Recommendation Report for Planning Permission for Works or Extension to a Dwelling

REF NO: FG/43/25/HH

LOCATION: 9 Sea Drive
Ferring
BN12 5HD

PROPOSAL: Ground and first floor front extensions, internal & external alterations including amendment to fenestrations and re-roofing. Erection of front wall and gates.

Drawing Title: GATE & WALL AS PROPOSED

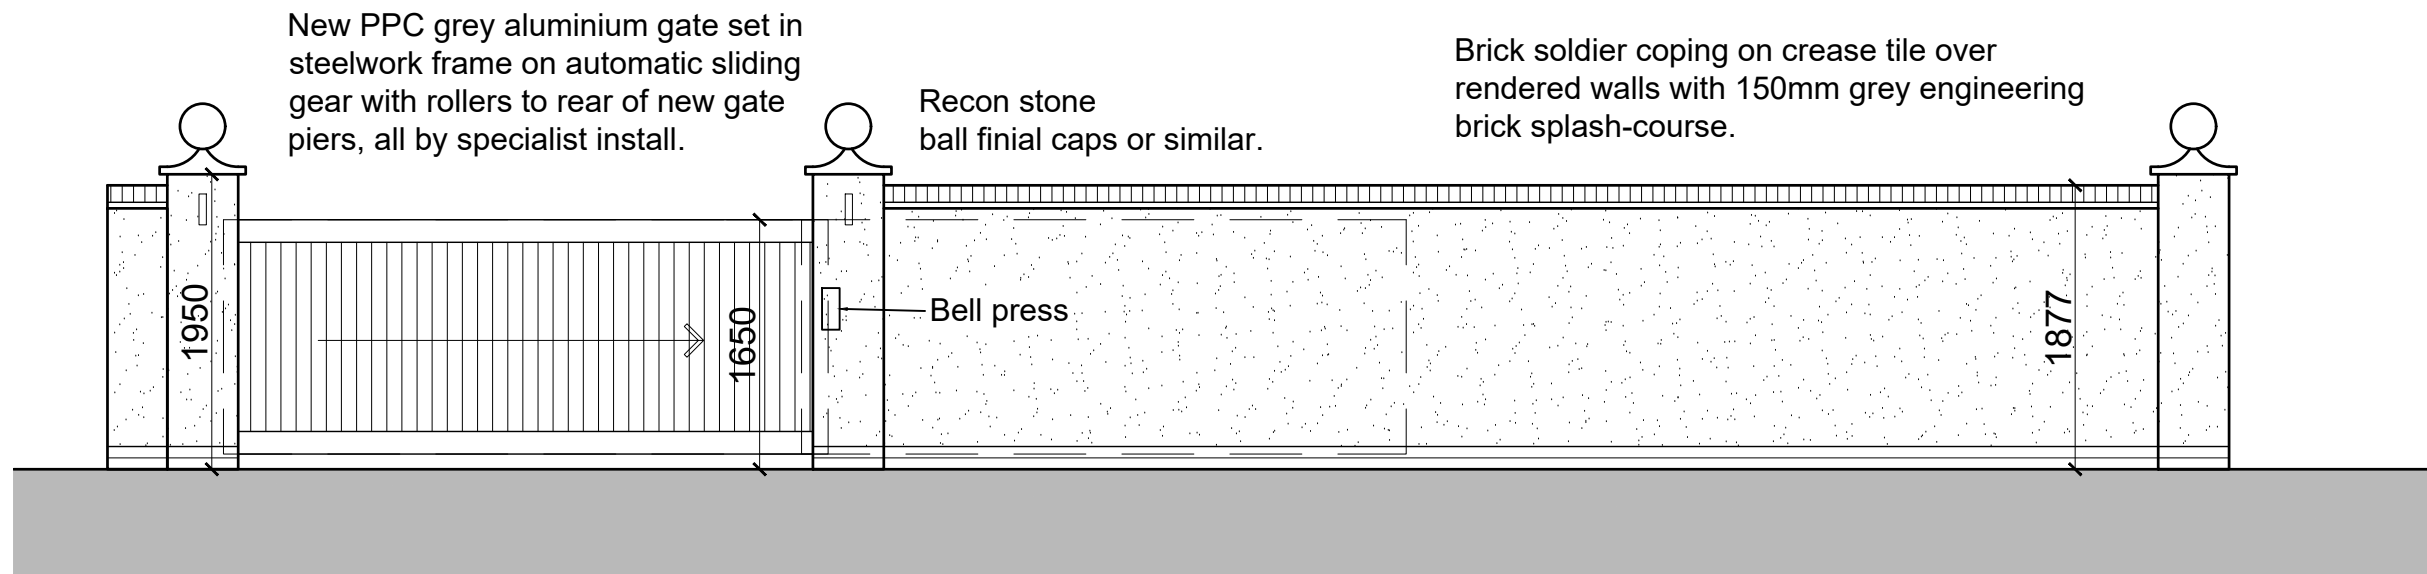
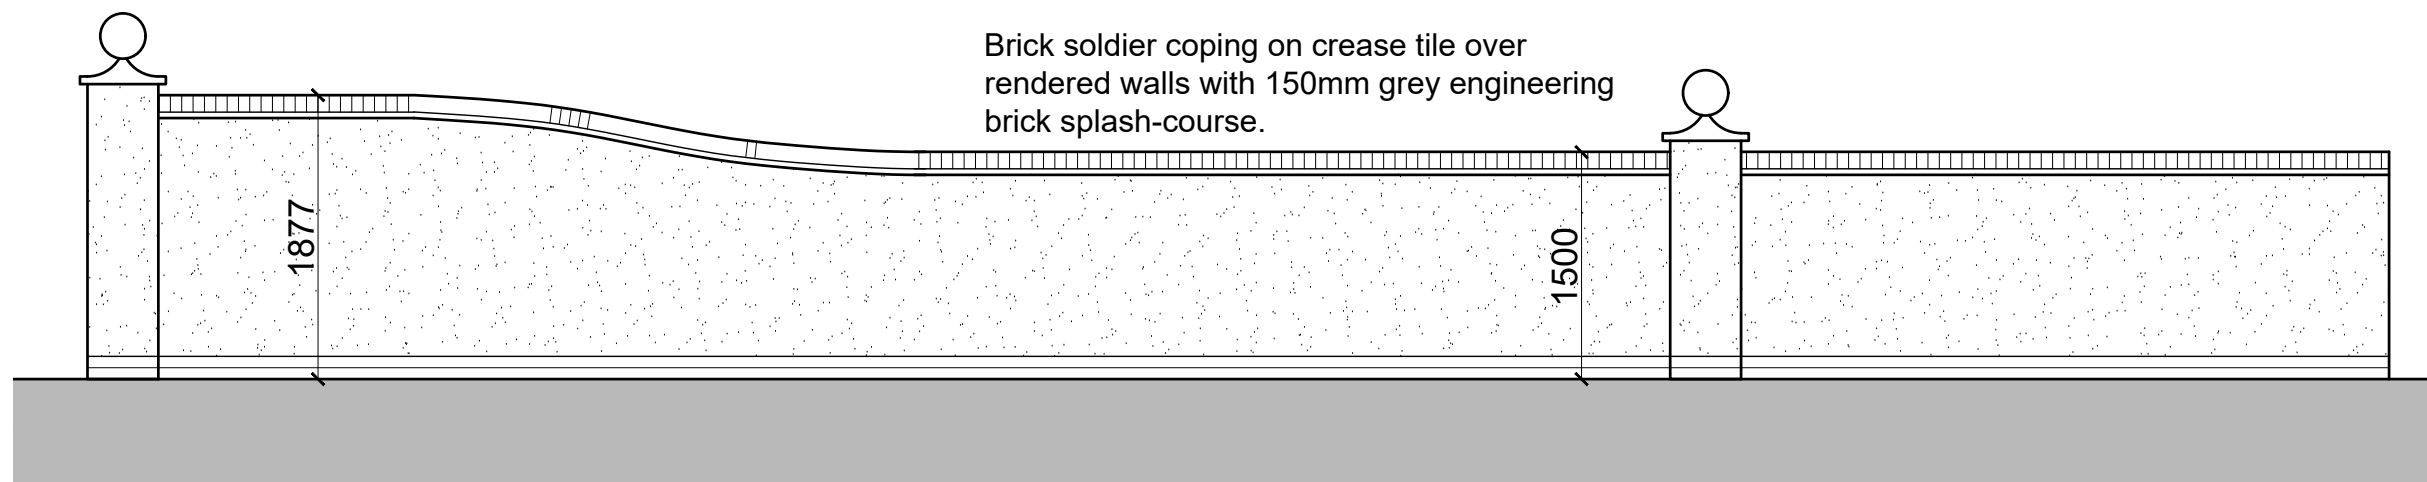
During the course of application determination, amendments were sought to reduce the height of the proposed front boundary wall and gate from 1.9m to 1.27m. These amendments were considered acceptable given the presence of similar low height boundary treatments to the front of properties along this street.

The amended front wall measuring 1.27m in height is proposed within the front (south) site boundary. The walls would be solid in appearance constituting of stone coping on rendered walls. A gate measuring 1.2m in height by 3.8m in width is proposed within the front boundary treatment. Given that there are examples of dwellings within this street scene with similar boundary treatments and gates to front. On balance, the addition of a front wall and gate to this property is not visually harmful to justify the refusal of planning permission on this basis.

Drawing Title: ELEVATIONS AS PROPOSED
Drawing Number: 147_105
Date: February 2025 | Scale: 1:100 @A3

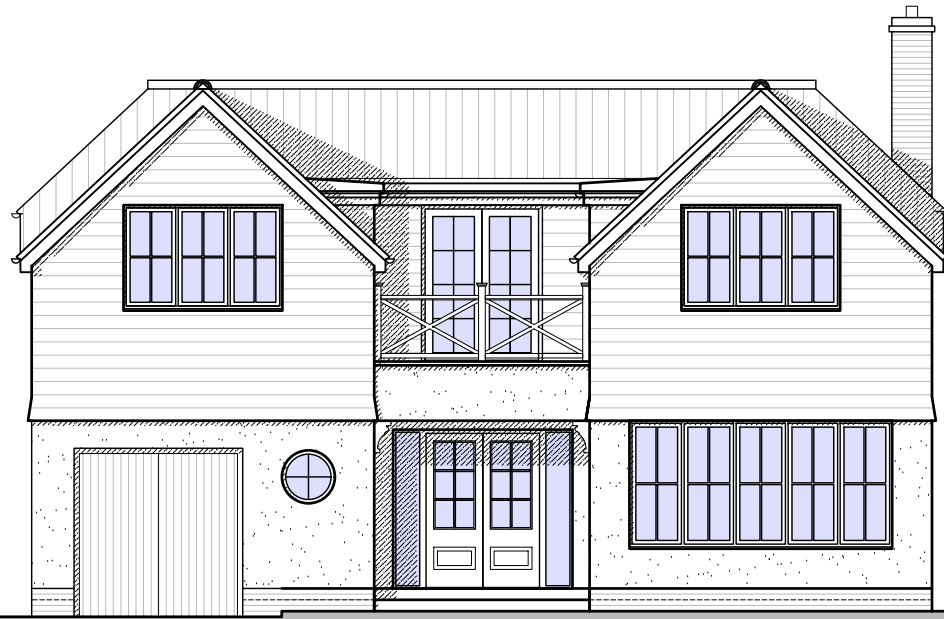
Following the demolition of the existing front (south) porch and bay window at ground floor level, a two-storey front extension is proposed. At ground floor level, the depth of the dwelling would be extended forward by 4.5m along the south-east. This extension would extend in line with the principal elevation of the dwelling. A small area (measuring 2.8m in width by 1.3m in depth) has been recessed at ground floor level to create a small open porch, with the flooring of the first-floor balcony acting as a roof cover for this area.

Following the demolition of the two front (south) dormers, the depth of the dwelling has been extended forward by approx. 4.5m to increase habitable floor area at first floor level. The extension would extend in line with the principal elevation of the dwelling featuring pitched roofs (to the extended sections) with eaves that would reflect the existing eaves height of the dwelling. A modest scaled balcony is proposed at first level above the open porch (ground floor). The extensions would feature two smaller gable end roofs, which adjoin the main roof of the dwelling at first floor level. It is noted that these roof elements are not set down from the main ridge line of the dwelling, however they are acceptable as they appear as an improvement to the existing roof design.

The proposed materials differ from those of the original dwelling. The walls of the main dwelling are to be finished with render at ground floor level similar to existing, the first-floor walls of the whole dwelling being finished with cement board cladding in the colour Taupe. Pitched roofs (existing and proposed) are to be finished with grey interlocking cement slates. All fenestrations will be of uPVC with Astragal bars.

To the front (south) elevation, fenestration is proposed at both the first floor and ground floor levels. These fenestrations would primarily overlook Sea Drive and would have no impact in terms of overlooking. A window is proposed to the side (east) elevation, this window would maintain a distance of 1.18m from the side boundary fence and given the presence of other windows along this elevation at first floor level, it is not reasonable to condition this window.
